AMENDED HILLS AT LORSON RANCH DIMENSIONAL STANDARDS & GUIDELINES

ORIGINAL PUDSP RECORDED AT RECEPTION NO. 220211670

THE HILLS AT LORSON RANCH
EL PASO COUNTY, CO
**PLANNED UNIT DEVELOPMENT AND
PRELIMINARY PLAN**
LOCATED IN THE NORTH HALF (N 1/2) SECTION 24 AND IN THE
SOUTH HALF (S 1/2) SECTION 13, T15S, R65W OF THE 6TH P.M.,
EL PASO COUNTY, STATE OF COLORADO

PUD DETAILS

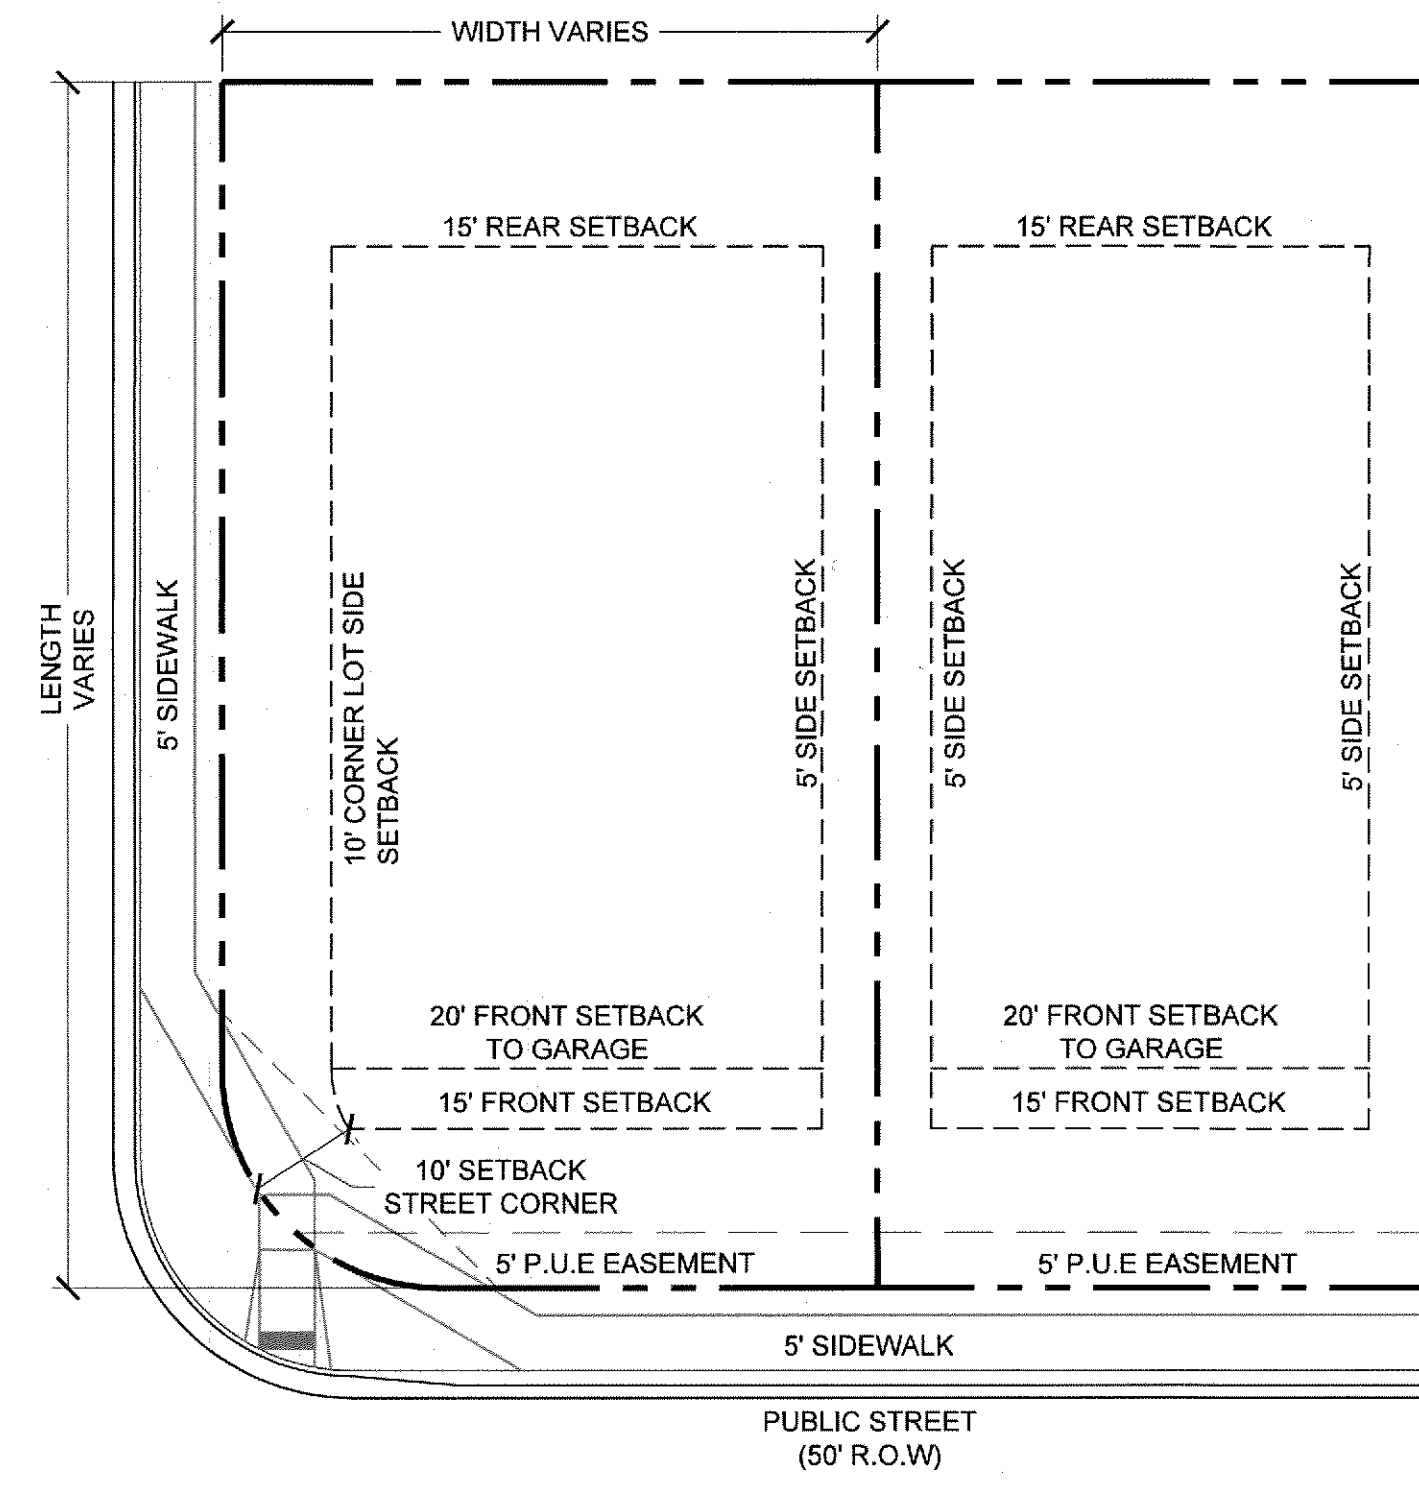
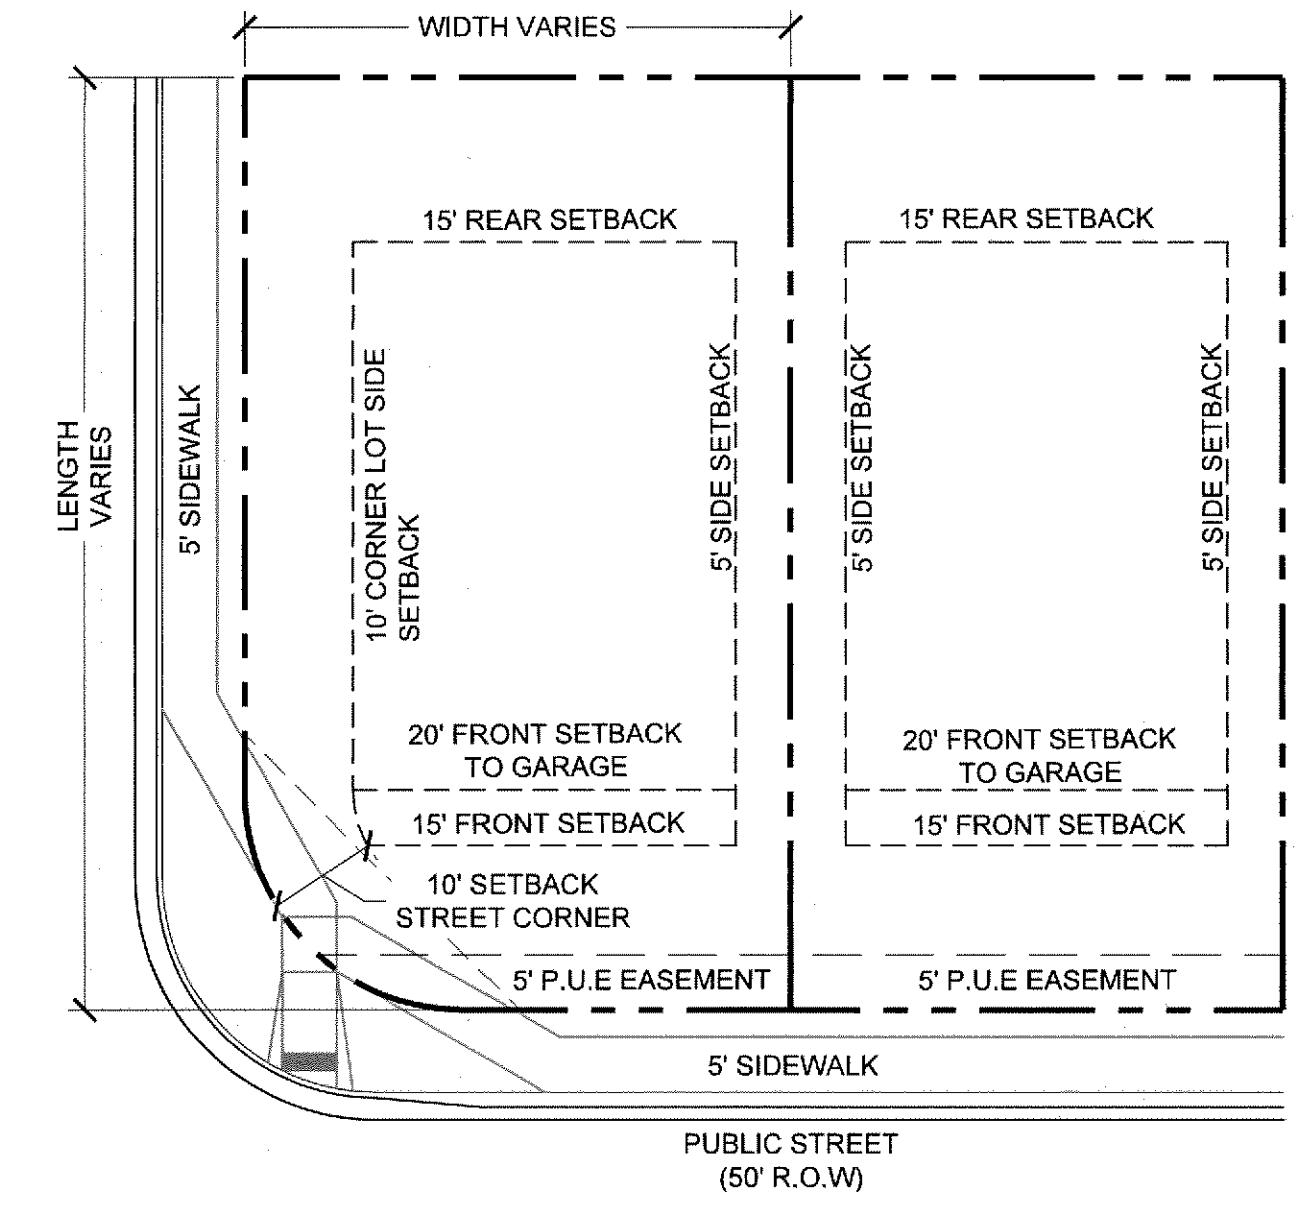
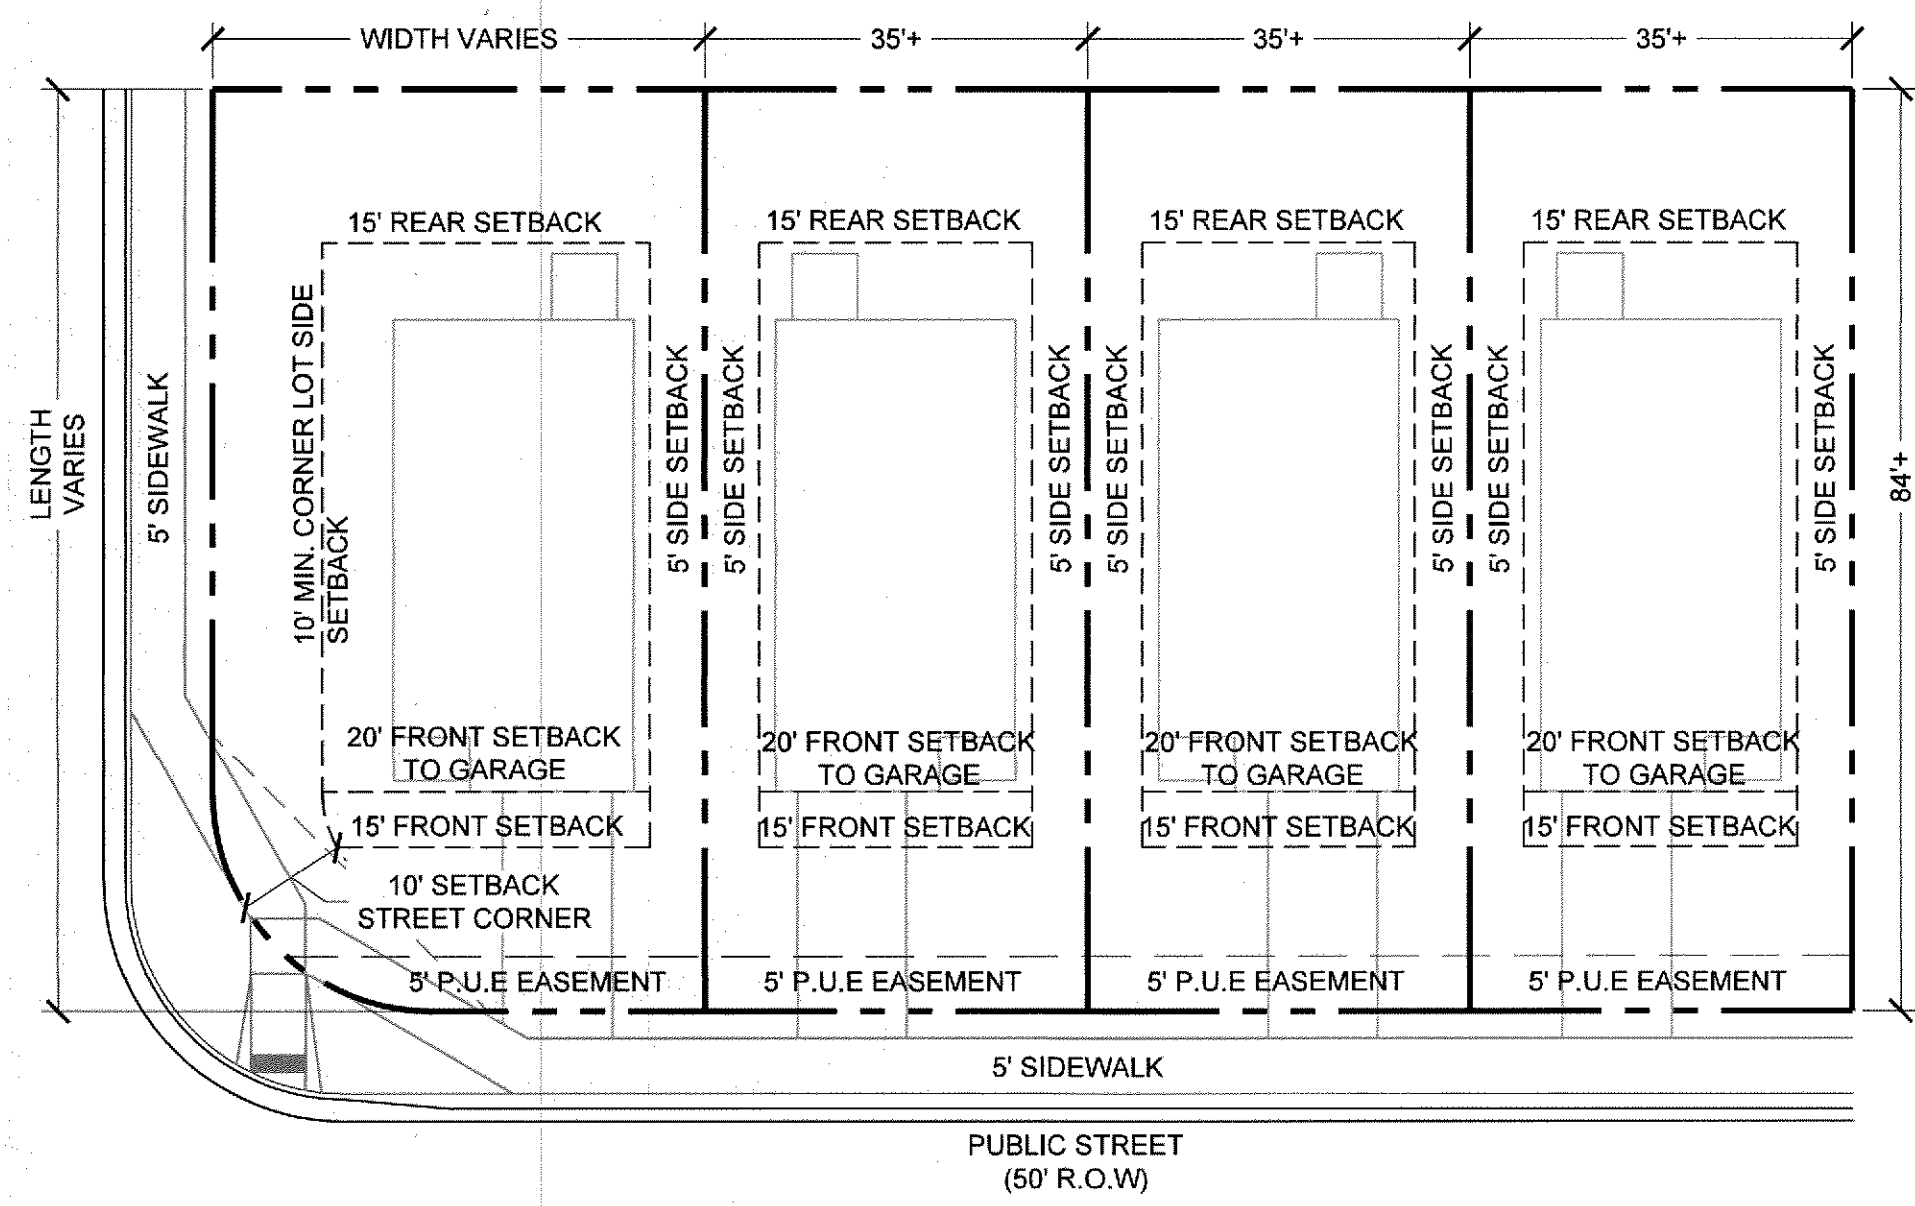
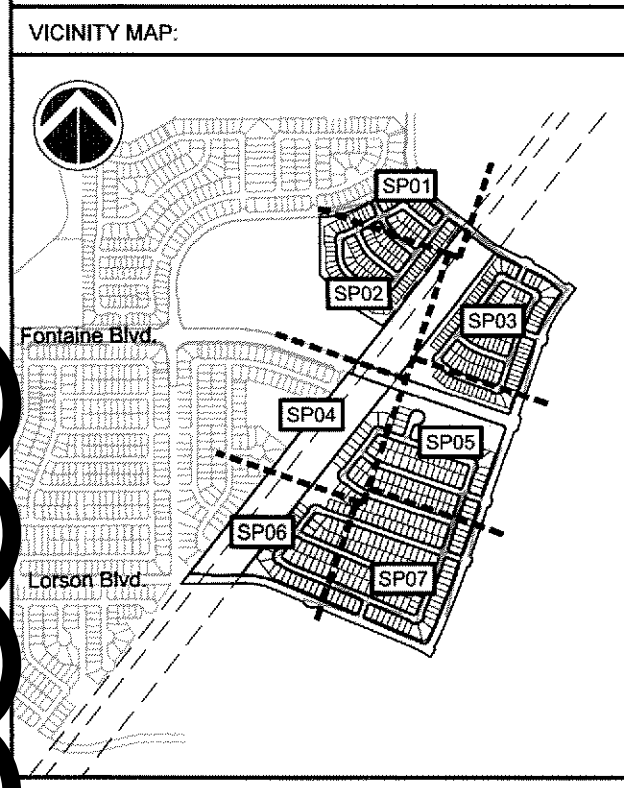
7. SETBACK REQUIREMENTS (SEE DETAILS):
 - a. FRONT YARD: TWENTY FEET (20') TO FACE OF GARAGE,
FIFTEEN FEET (15') TO FACE OF HOUSE. — delete comma
 - b. SIDE YARD: FIVE FEET (5', 10' MIN. BETWEEN BUILDINGS). — add comma
